From: Sarah Burrow <Sarah.Burrow@arun.gov.uk>
Sent: 03 February 2022 09:03
To: Planning.Responses <Planning.Responses@arun.gov.uk>
Cc: Anita Gardner <Anita.Gardner@arun.gov.uk>; Paul Cann <Paul.Cann@arun.gov.uk>
Subject: RE: Planning Consultation on: R/298/21/PL

Application No: R/298/21/PL

Site Address: Land at Rustington Retail Park New Road Rustington BN16 3RT

Description of Works: Erection of a drive-thru coffee shop (Use Class E) with associated parking, service arrangement, landscaping and associated infrastructure. This application is in CIL Zone 4 (zero rated) as other development.

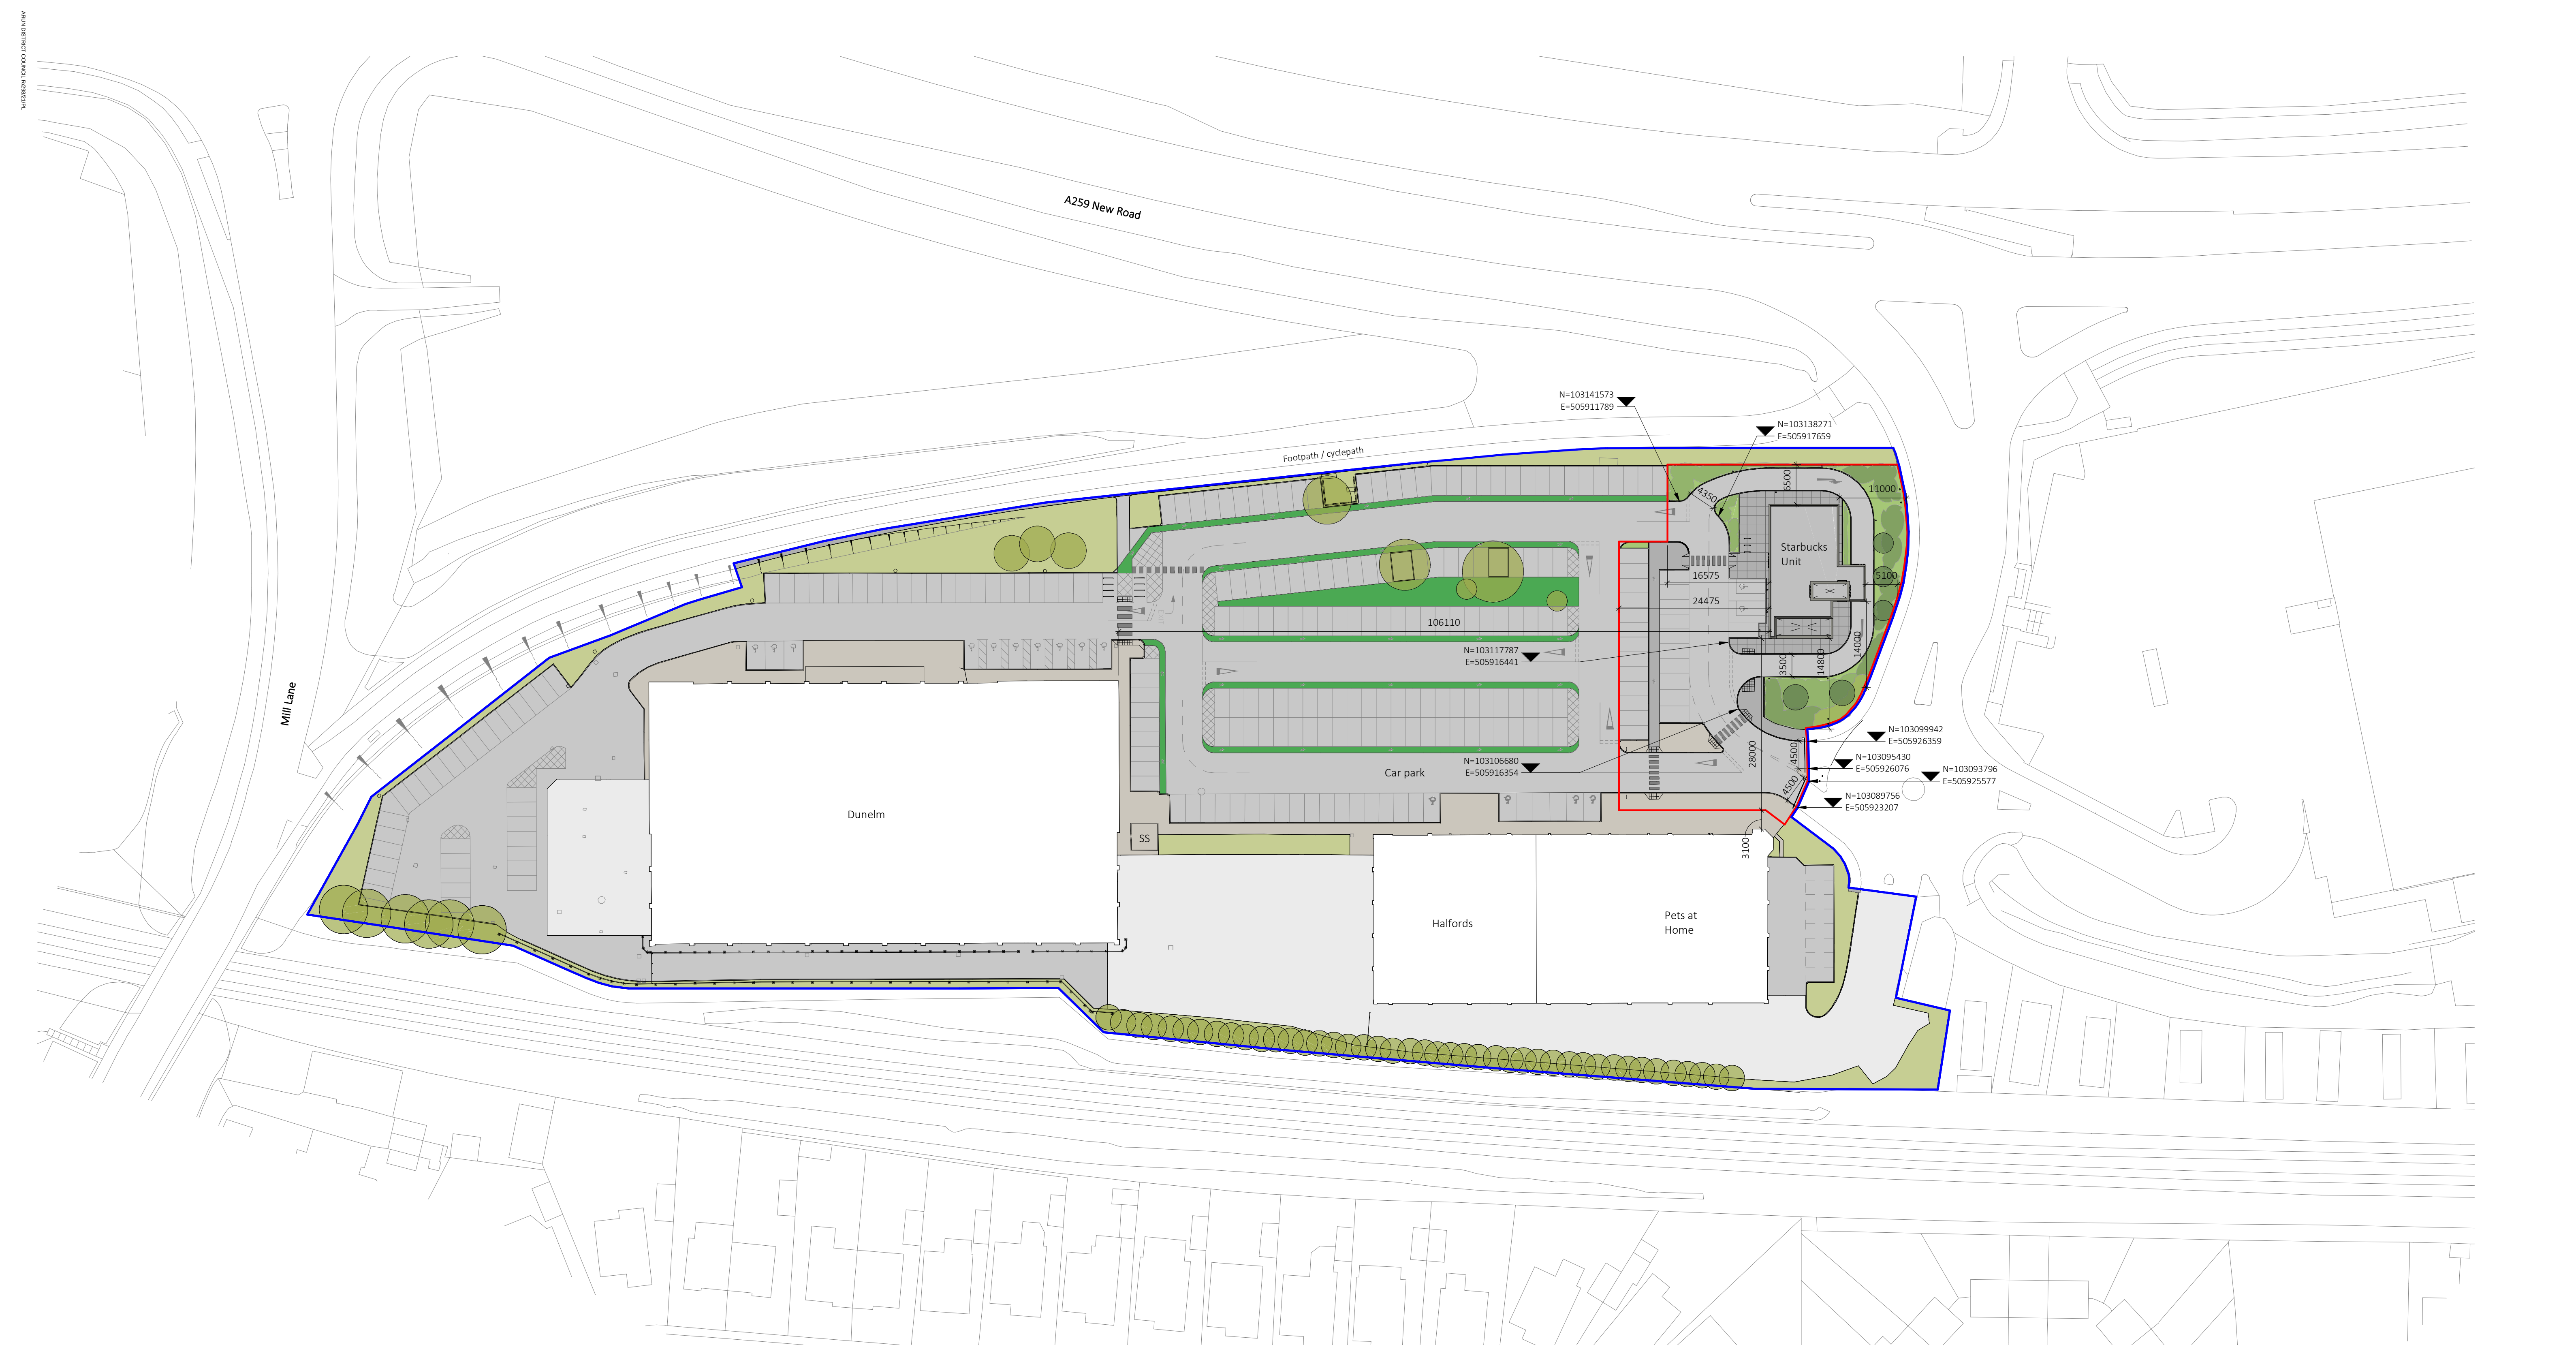
Please can the applicant confirm that the precise location of culverts north and south (running to north--east) of the proposed drive-through? Please can they also confirm and show on the drawings that the proposed building is at least 3m from both culverts. Assuming that this information can be provided, then we would be unlikely to request conditions due to the scale of the proposed development and the existing nature of the site.

Any additional connection to either watercourse would require ordinary watercourse land drainage consent.
